Article 21 of the Town and Country Planning (General Development Procedure) Order 1995
Applicaton for details reserved by conditions 4 (stationing of vehicles) and 5 (replacement car
parking spaces) following a grant of planning approval EG/9/07/
Commercial House Fontwell Avenue,Eastergate,

Arun District Council have decided to **REFUSE details reserved by condition for the following reasons:**

REVISION			
PROJECT		Proposed Development at Commercial House, Fontwell Avenue	
SUBJECT		Site Plan - showing proposed parking spaces	
SCALE	DATE	DRAWING No	
	Jan 2013	06 / 67 / 17	
DRAWN	CHECKED

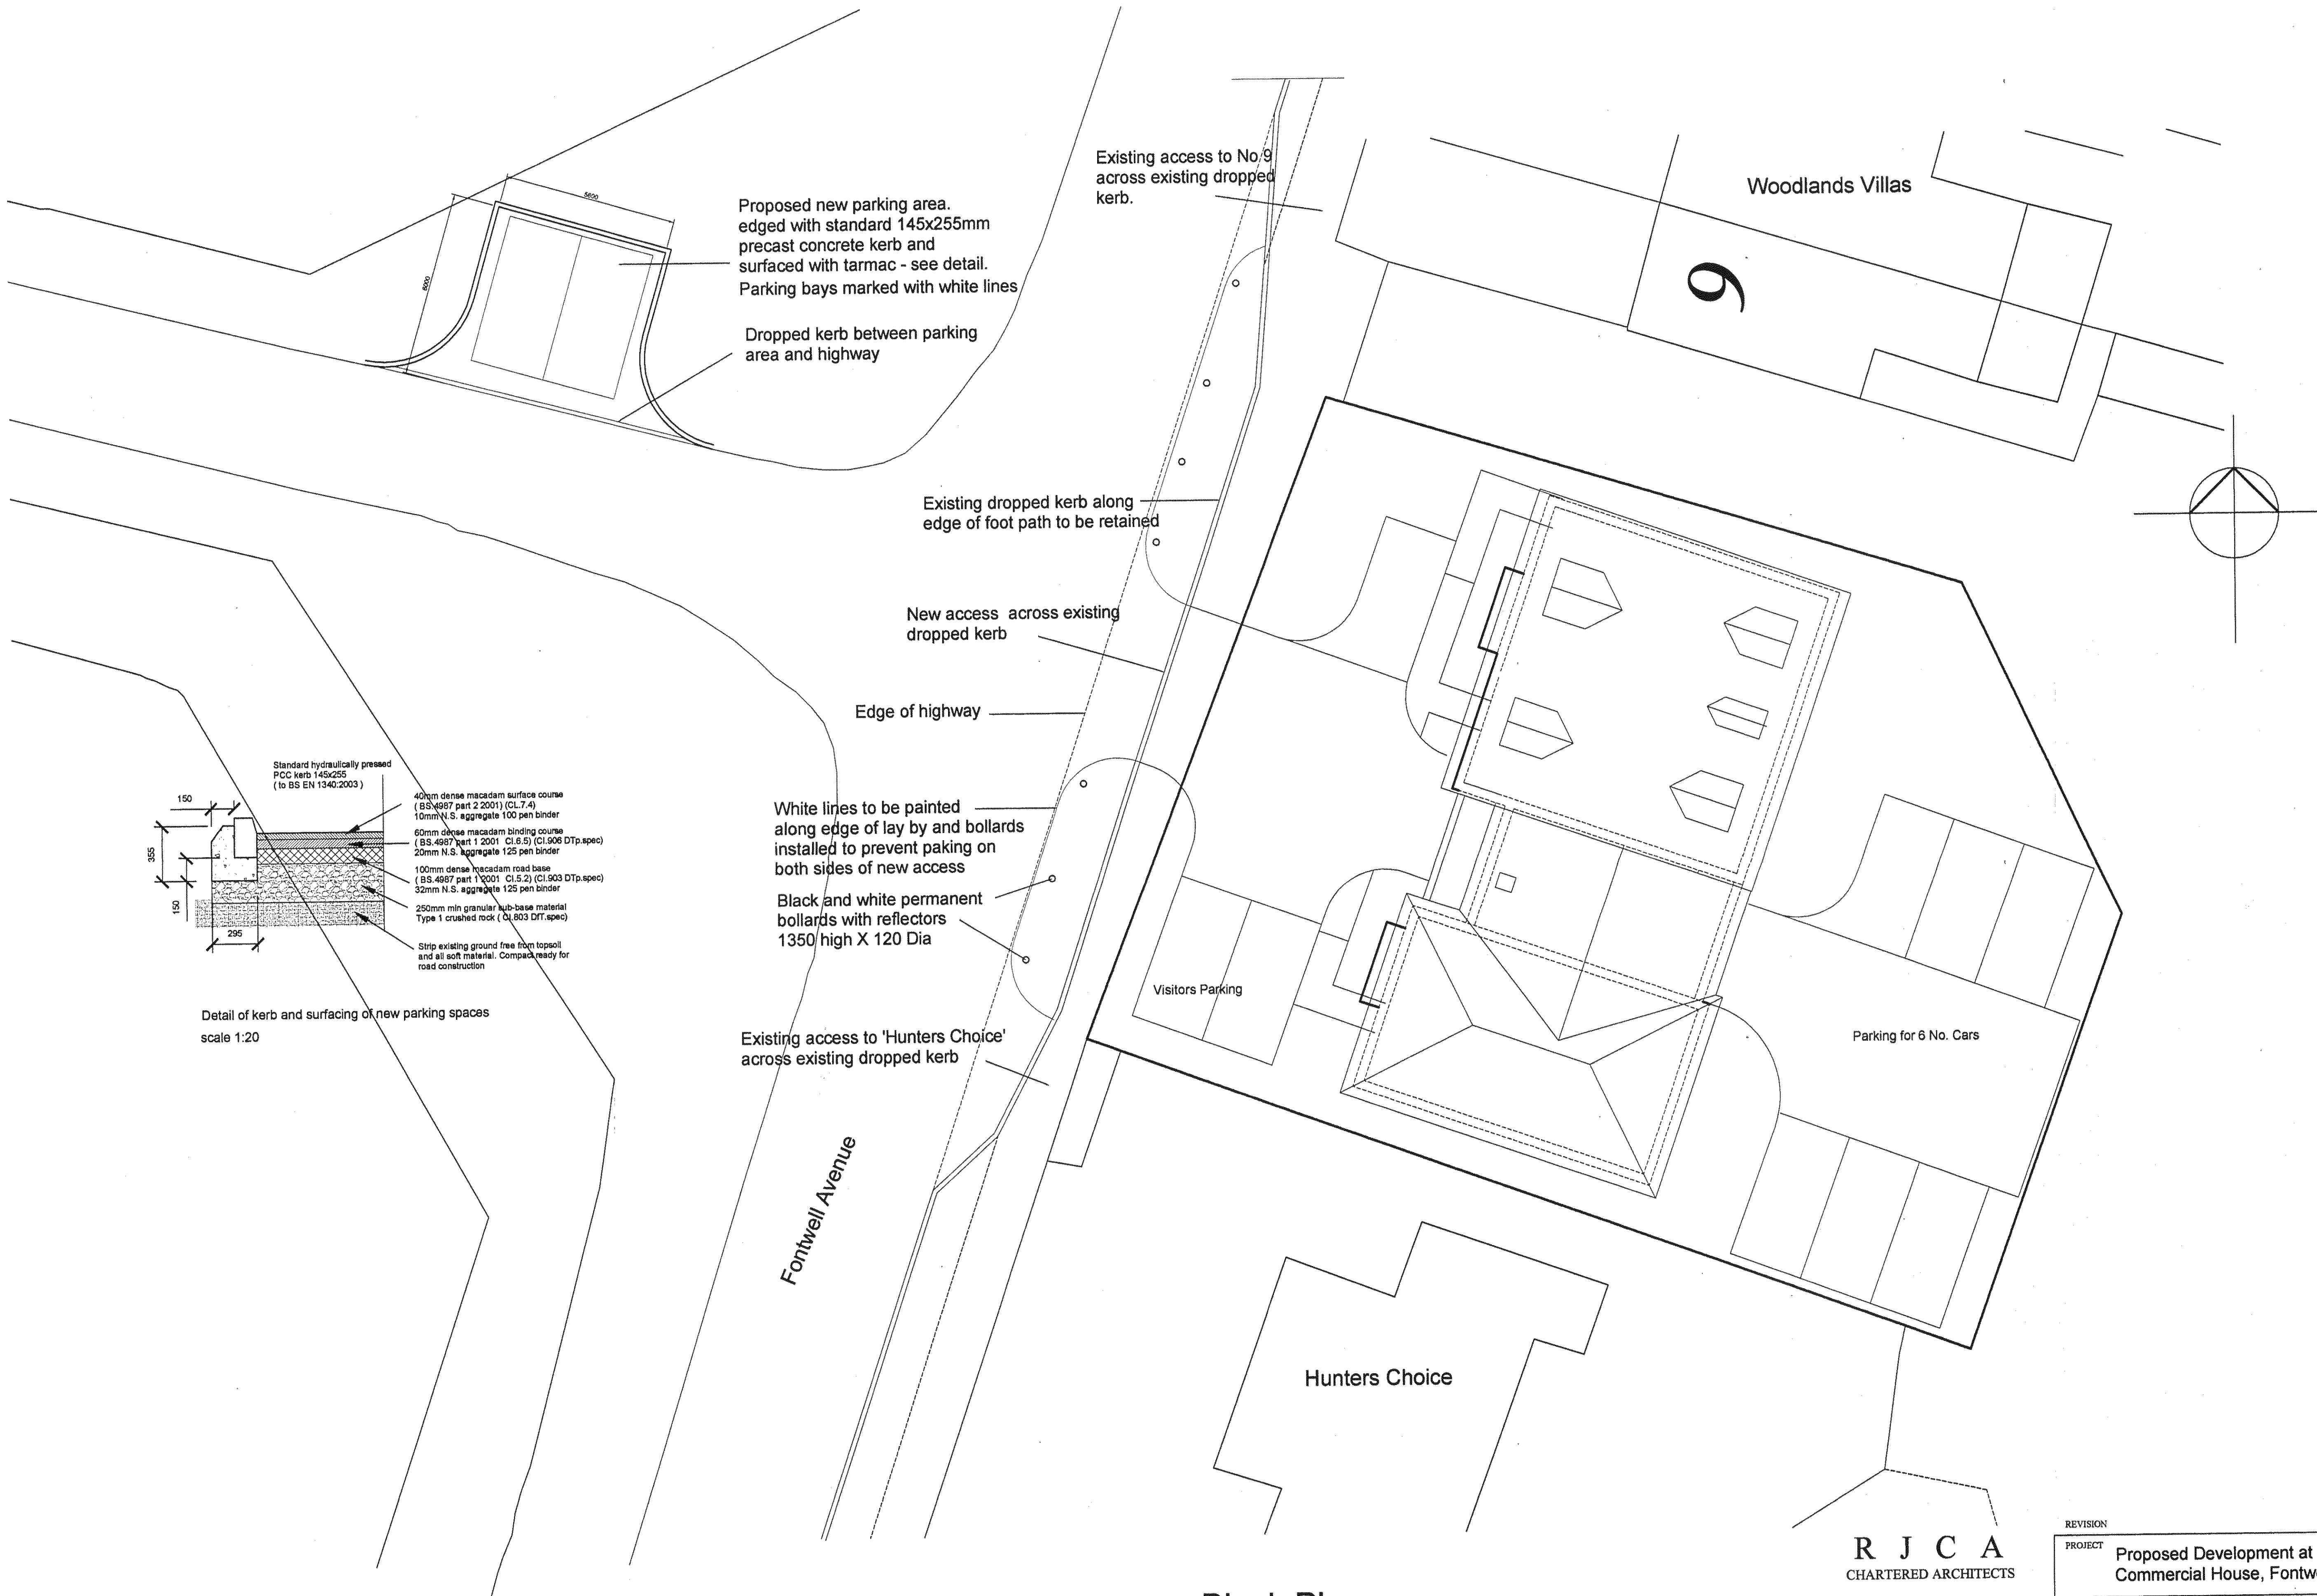
With respect to the details provided in connection with condition 5 of application EG/9/07, West Sussex County Highways agrees in principle to the proposed car parking spaces submitted in drawing 06/67/17. However, West Sussex County Highways would advise that the Highways Authority's mechanism for checking the acceptability of works within the highway is by way of Section 278 Agreement.

At present, the applicant has not made an application to enter into a Section 278 Agreement. Hence, whilst the broad details have been accepted through the planning process, it would be premature to discharge the condition prior to the submission of a S278 application. The applicant is requested to contact the Implementation Team Leader (01243 642105) to commence this process. The applicant is advised that it is an offence to undertake any works within the highway prior to the agreement being in place.
